MOD 6 - transfer floor area to child care centre use (SSD-5175-Mod-6)

Request for Additional Information

**Figure 2 Comparison of approved and proposed Concept Plan**

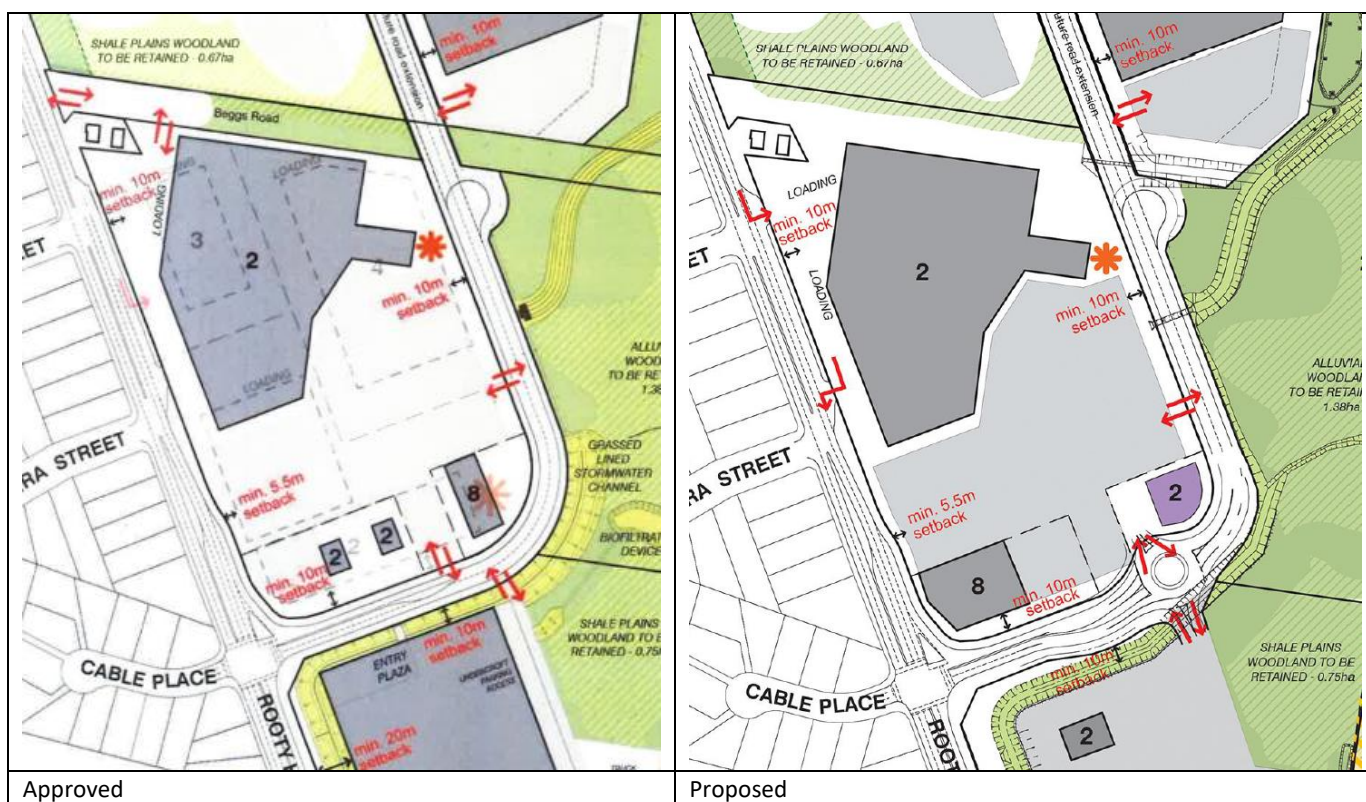
You are requested to update the concept plan to be consistent with Setback control C1 - a 10m minimum front building setback to Rooty Hill Road South from the child care centre (page 49 of the design guidelines).
